The Drovers Solar Farm

Applicant's Response to ExQ1

PINS reference: EN0110013

Document reference: APP/8.6 (Original)

DRAWING TITLE:
ES Figure 12.15 Work No. 4 Piling Locations within
CSA for Maximum Groundwater Level

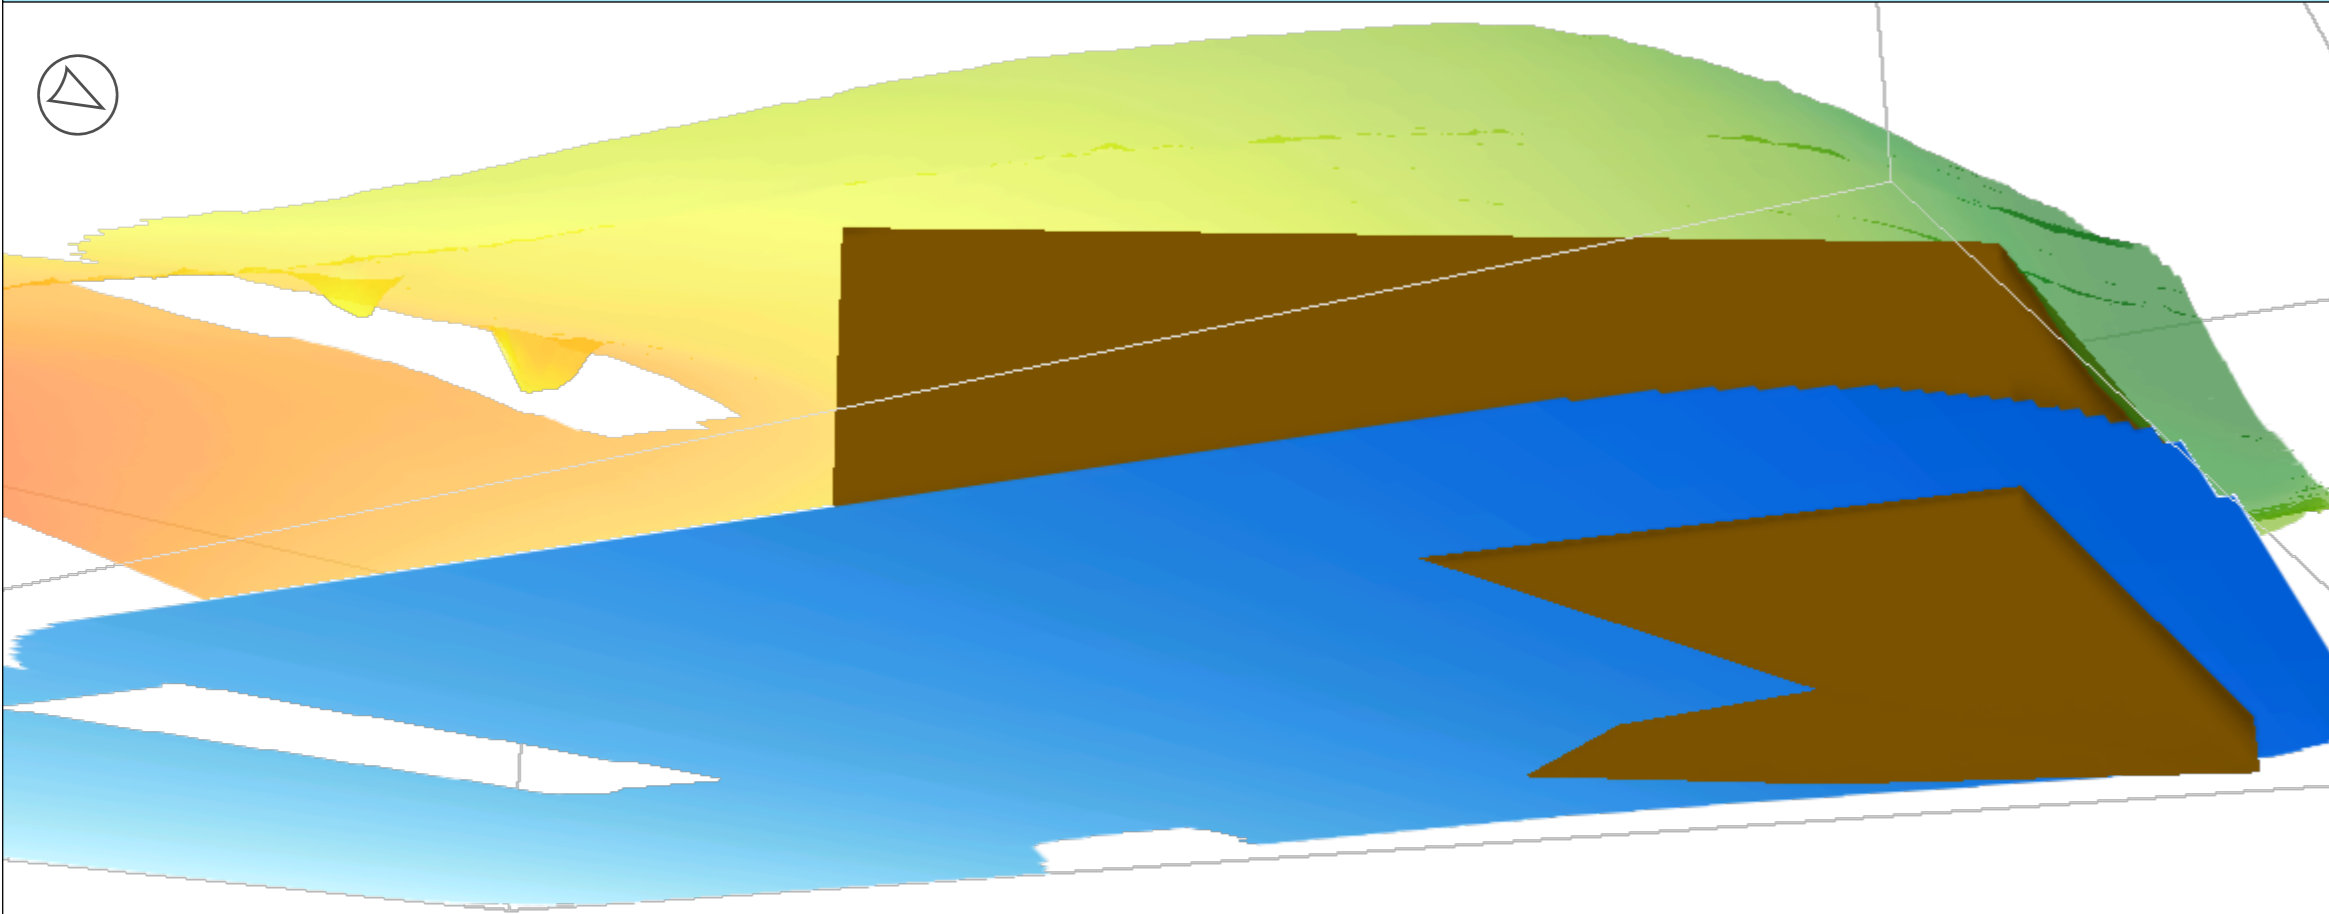
ExQ	Respondent	Question	Applicant’s Response
Q8.0.1	The applicant	<p>Effects on groundwater during construction</p> <p>ES Chapter 12: Water Resources [APP-061], Table 12-20 identifies that for groundwater additional mitigation of a piling foundation risk assessment is proposed to mitigate the effects of chemical pollution and erosion sedimentation. The outline Construction Environmental Management Plan (oCEMP) [APP-186] does not provide any further detail of a piling foundation risk assessment.</p> <p>Could the applicant provide further detail on how this risk assessment would mitigate the risk and how this would be secured in the dDCO?</p>	<p>A piling foundation risk assessment (FWRA) will identify, evaluate, and control pathways through which piling activities could impact groundwater, once the design of foundations has been chosen.</p> <p>All piling and foundation methods will be determined via a FWRA, following groundwater monitoring, and this has been updated within the oCEMP [APP/7.6.1] submitted at Deadline 1. Groundwater monitoring will be undertaken over a sufficient period to be representative of seasonal variation including worst-case groundwater levels and thus should include monitoring for at least six months, including the winter period, and the commitment in the oCEMP requires approval from the Environment Agency before the monitoring commences.</p>
